**Notice of Exhibition – Locomotive Workshops (Bays 1-4A), Australian Technology Park,
Eveleigh (SSD 8517)**

Thank you for your letter dated 13 November requesting Transport for NSW (TfNSW) review and comment on the above.

Proposed Plan Locomotive St

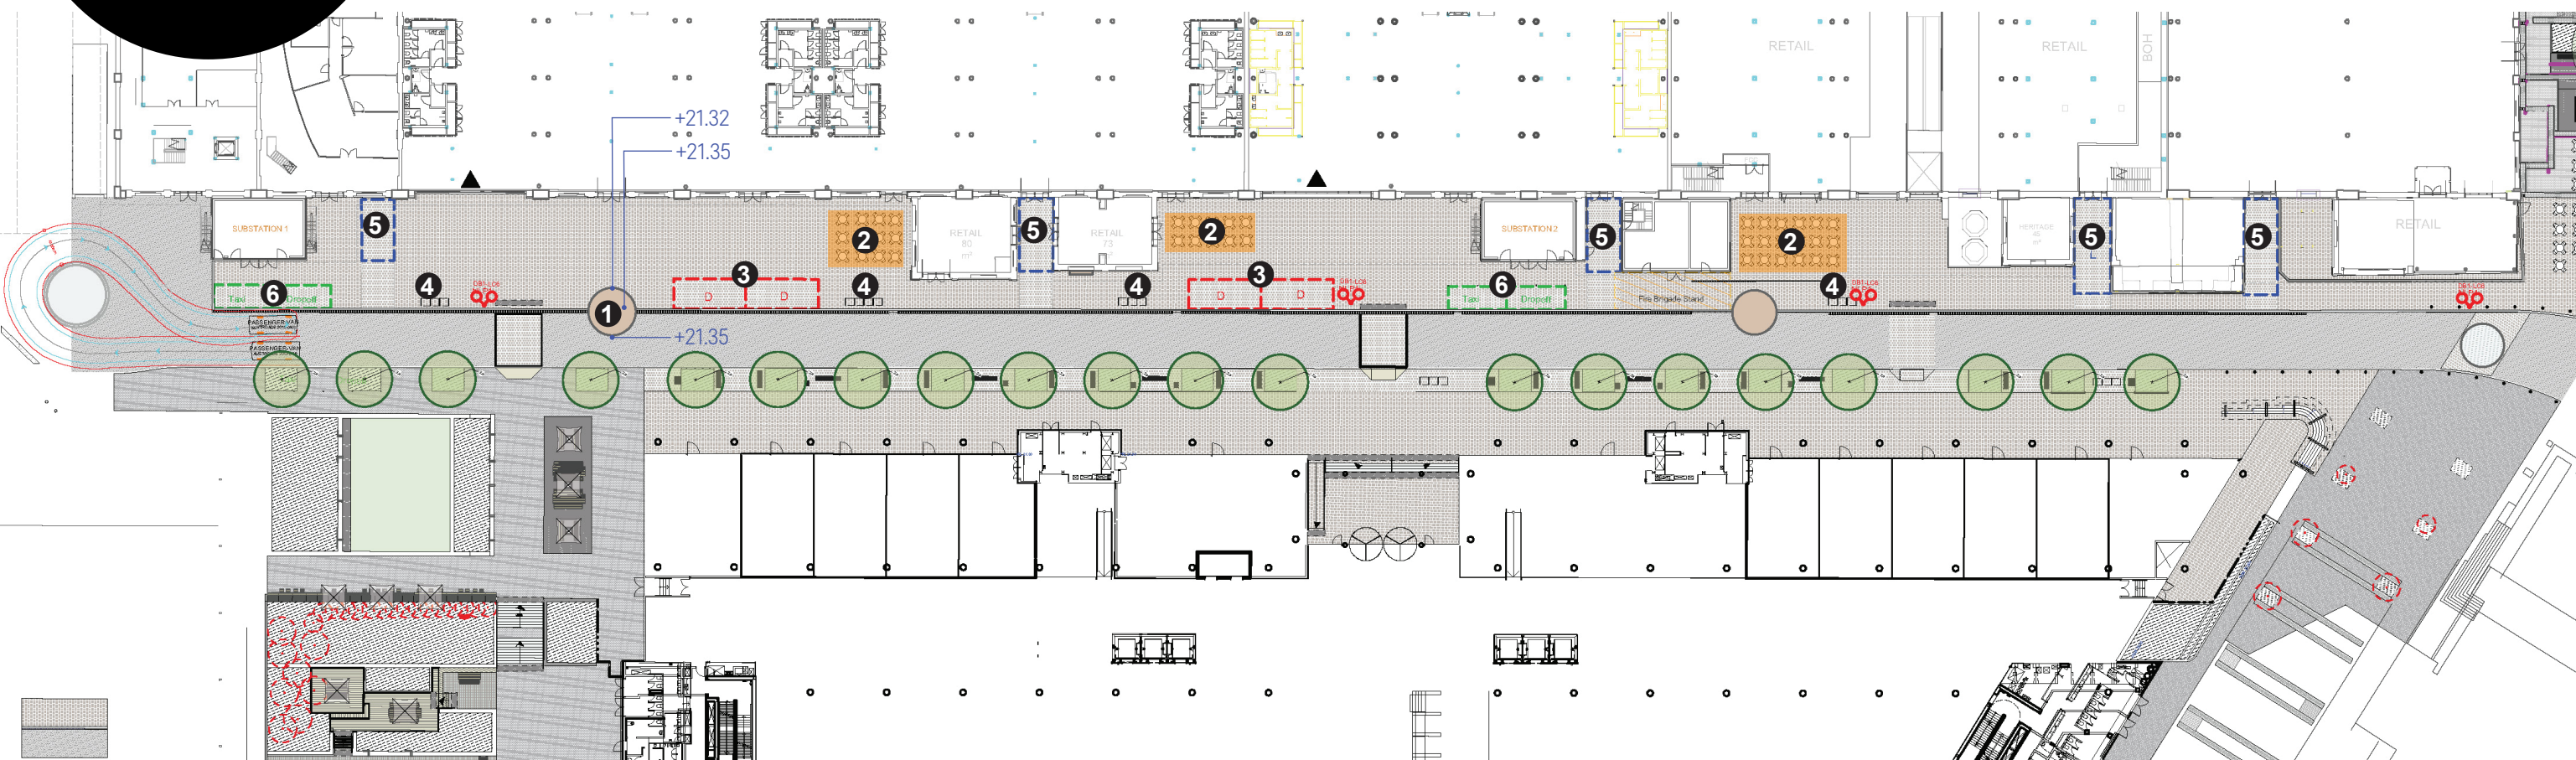
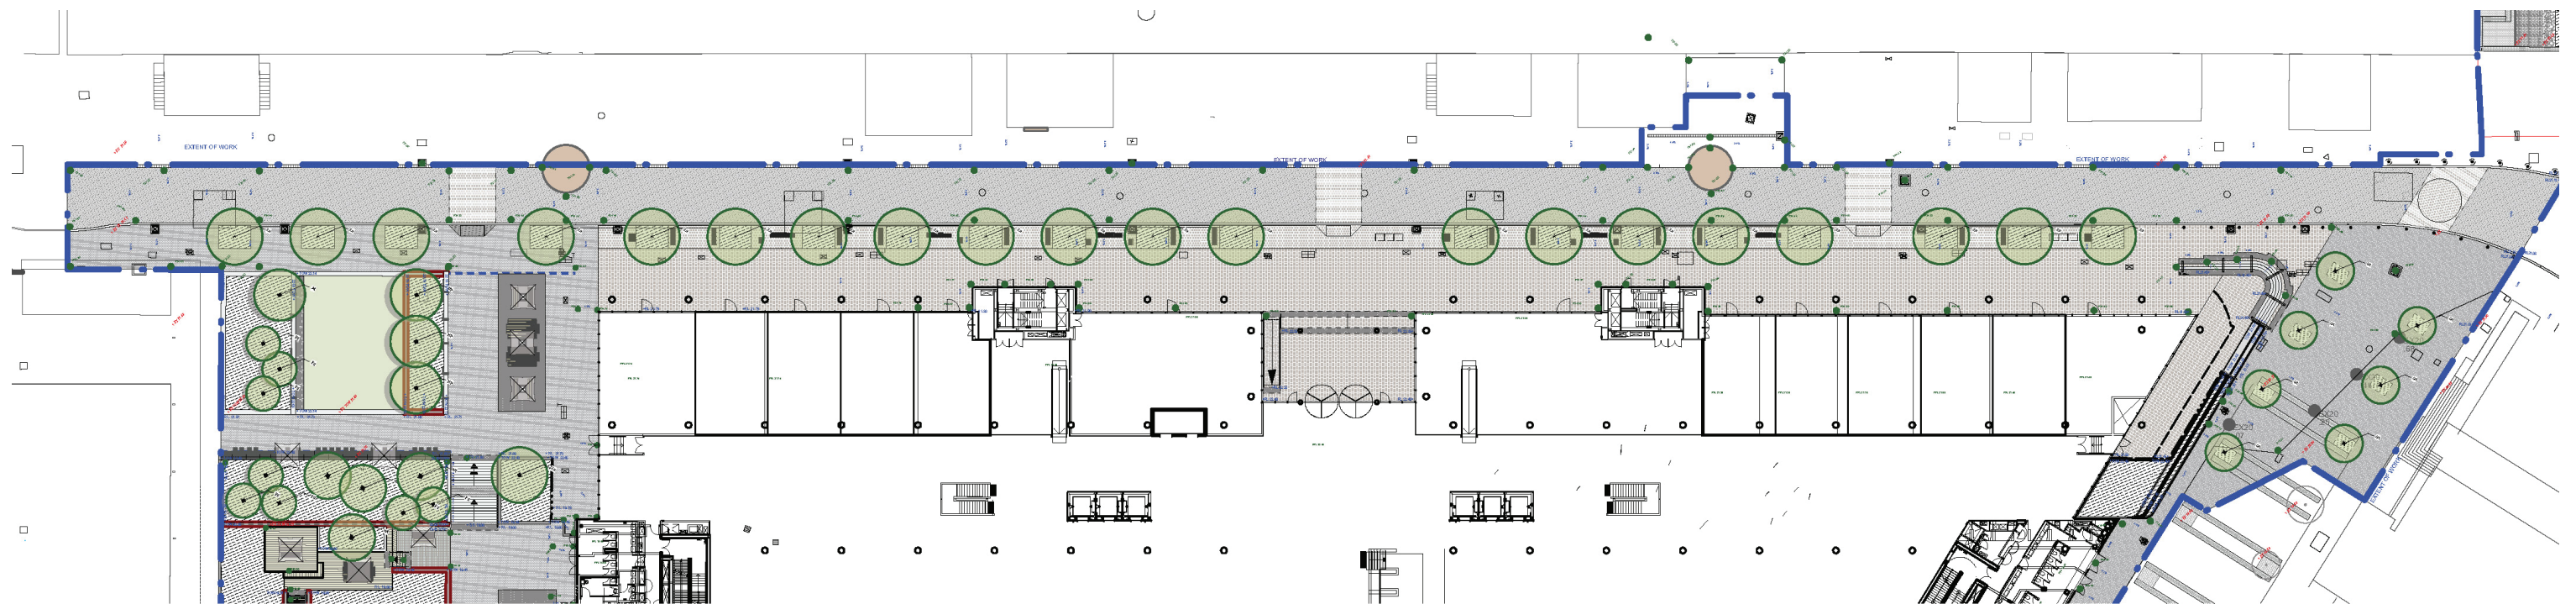
Locomotive Street is proposed to be upgraded as part of the public domain works under the SSD 7317 development. TfNSW requests that the proponent continue to work with TfNSW to resolve the design for Locomotive Street, in particular the provision for coaches. Any works that occur in Locomotive Street as part of this application should not occur until the design of Locomotive Street is resolved.
